**RE: College of Fine Arts (COFA) Redevelopment - MP 08_0104
University of New South Wales, Paddington Campus**

Section 75W Modification – Block D

This amendment seeks to modify minor aspects of the approved Block D. The consent is to be amended to refer to a new set of plans for Block D, prepared by Architectus, titled “UNSW-COFA Gateway” dated July 2010, being Drawing Nos:

issue
A0-01

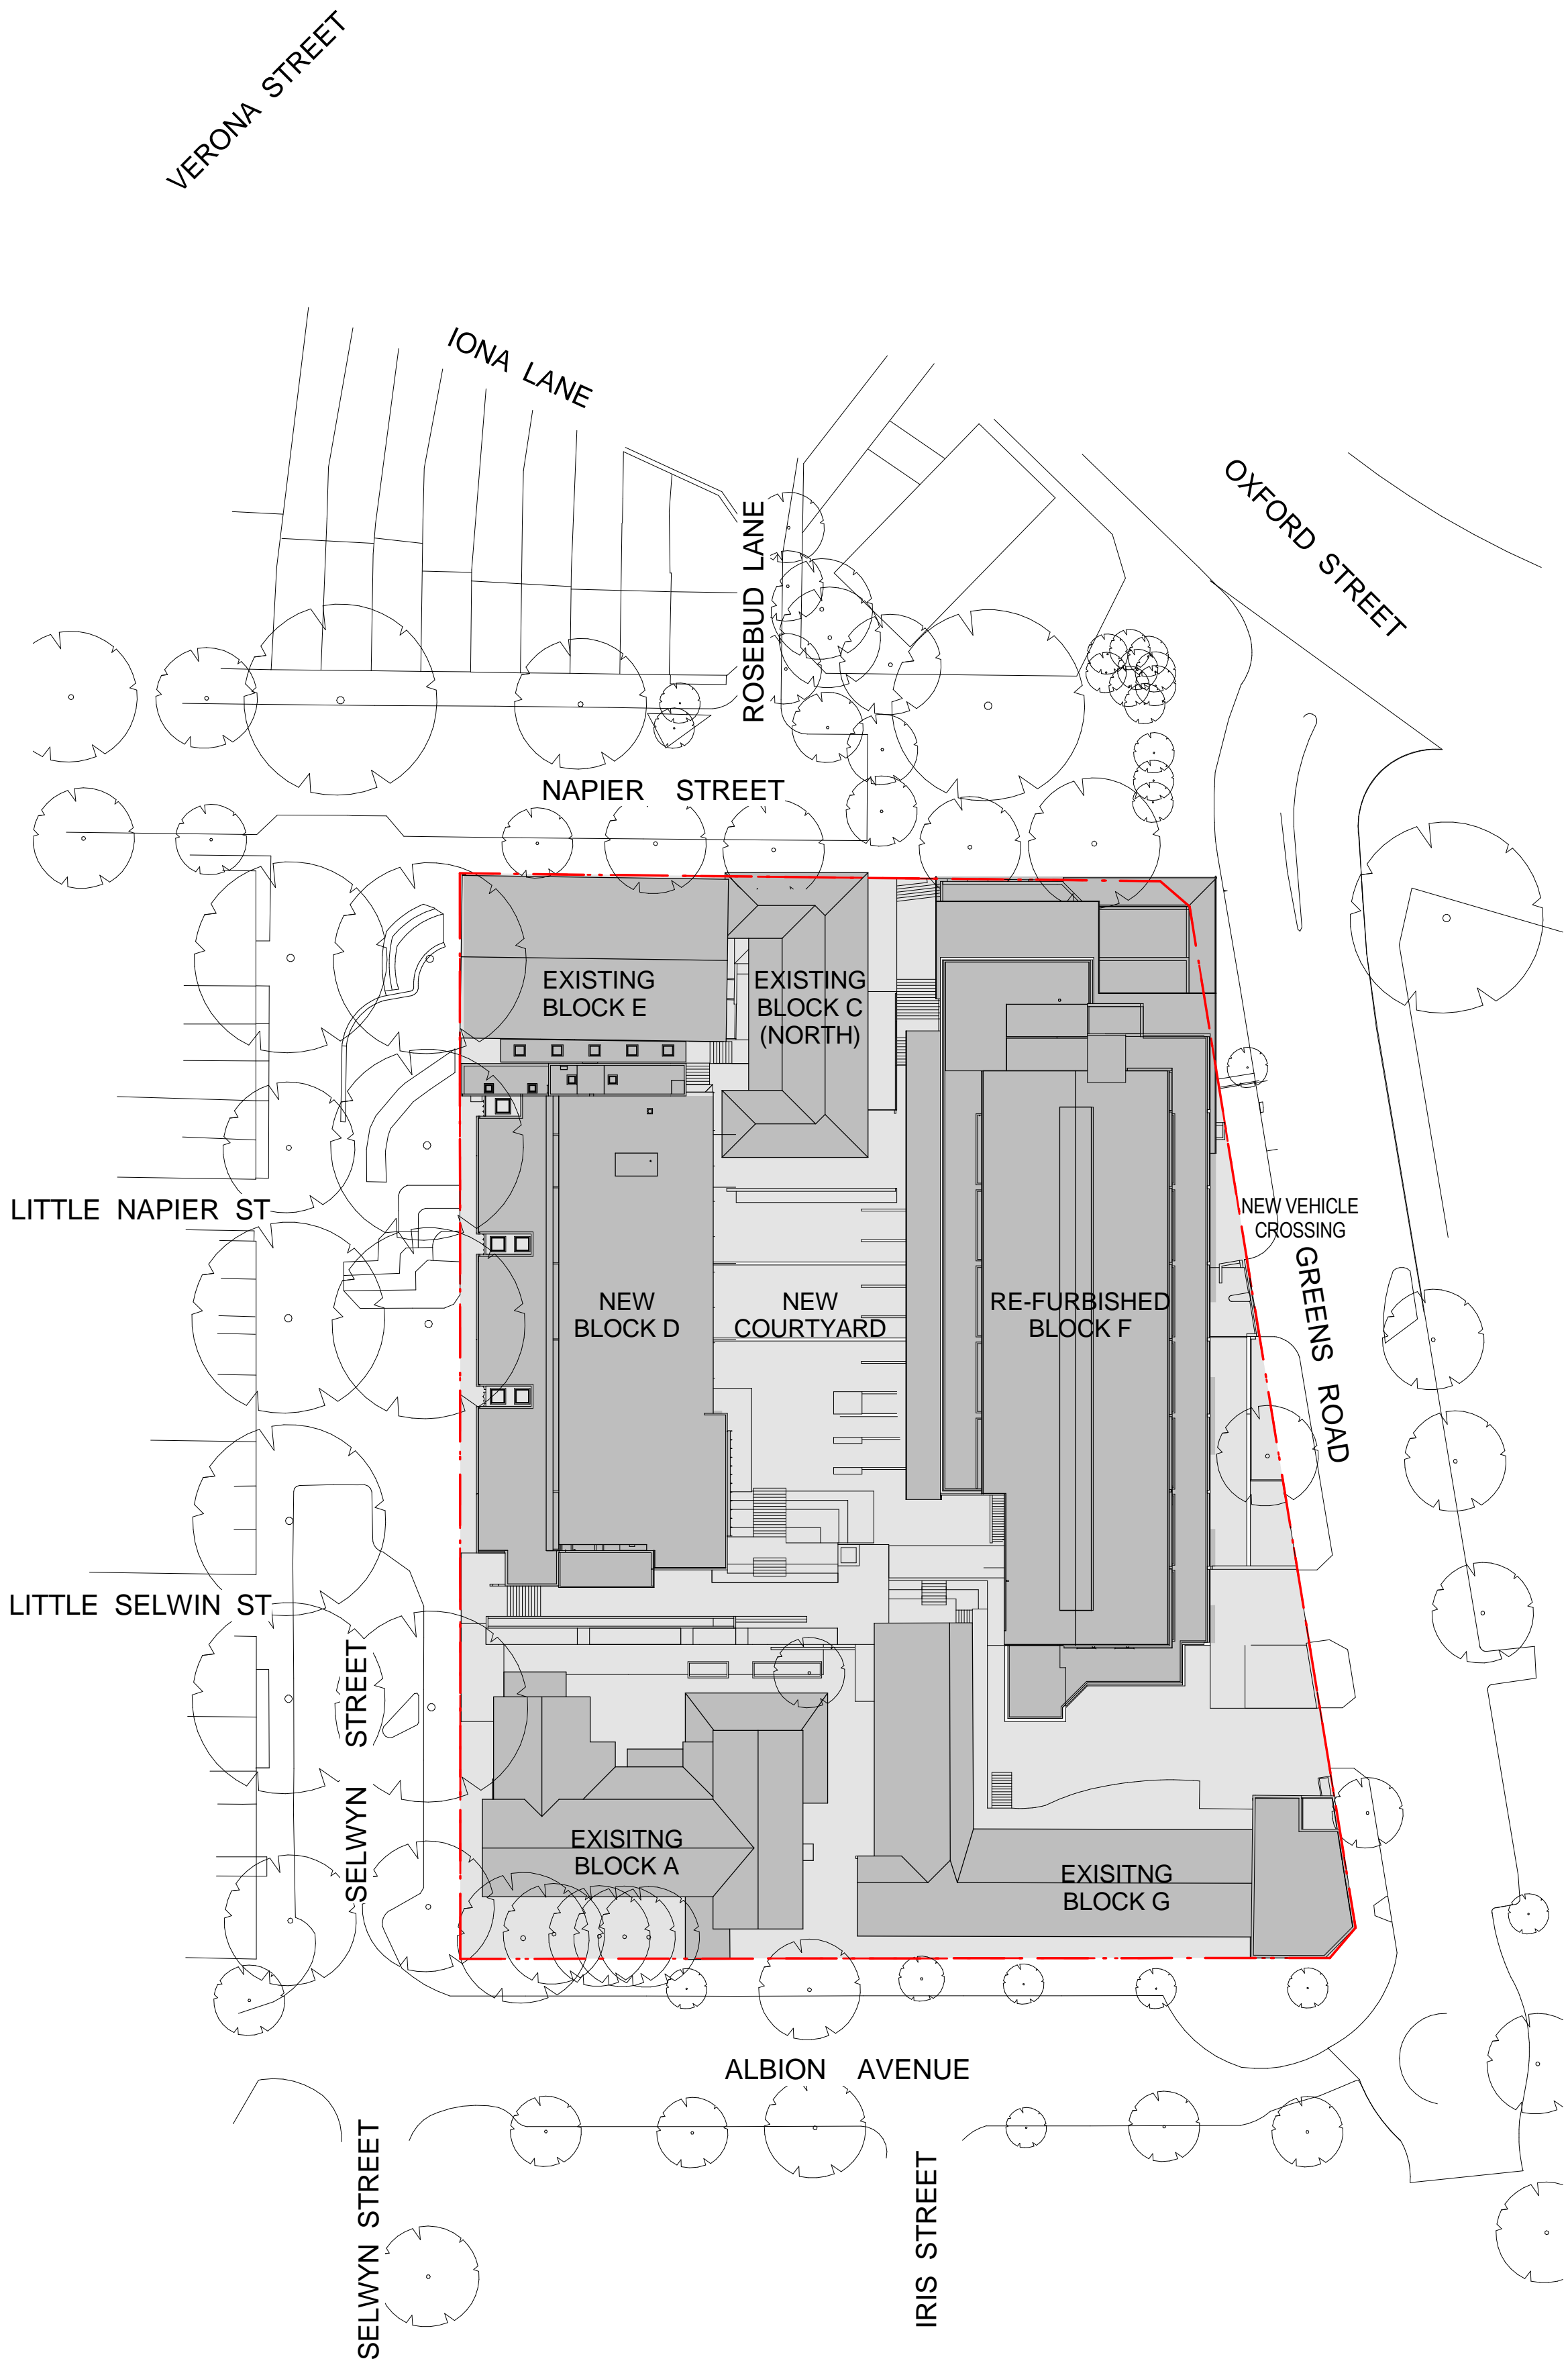
Approved Dwg No	Amended Dwg No	Element	Proposed Modifications	Reason for Modifications	Impact of Modifications
A0-01 B	A0-01 C	Drawing List Site Plans	Revised to reflect Block D changes.	Drawing consistency.	Nil.
A0-02 B	A0-02 C	Shadow Diagrams	Revised to reflect Block D changes.	Drawing consistency.	Shadow impact on Selwyn Street marginally decreased.
A1-01 B	A1-01 C	Overall Plan – Basement (Formerly Level 1)	<ul style="list-style-type: none"> Block D relocated 1630mm to east away from Selwyn Street boundary. Gridlines adjusted to reflect new position. Lightwells omitted from Basement. Internal fit-out for plant and education uses. 	<ul style="list-style-type: none"> Response to arborist advice. Increased setback alters set-out lines. Proposed use of basement precludes need for daylight. Internal space allocations and fit-out now proposed. 	<p>Increased protection for trees; decreased shadow impact.</p> <p>Nil.</p> <p>Nil</p>
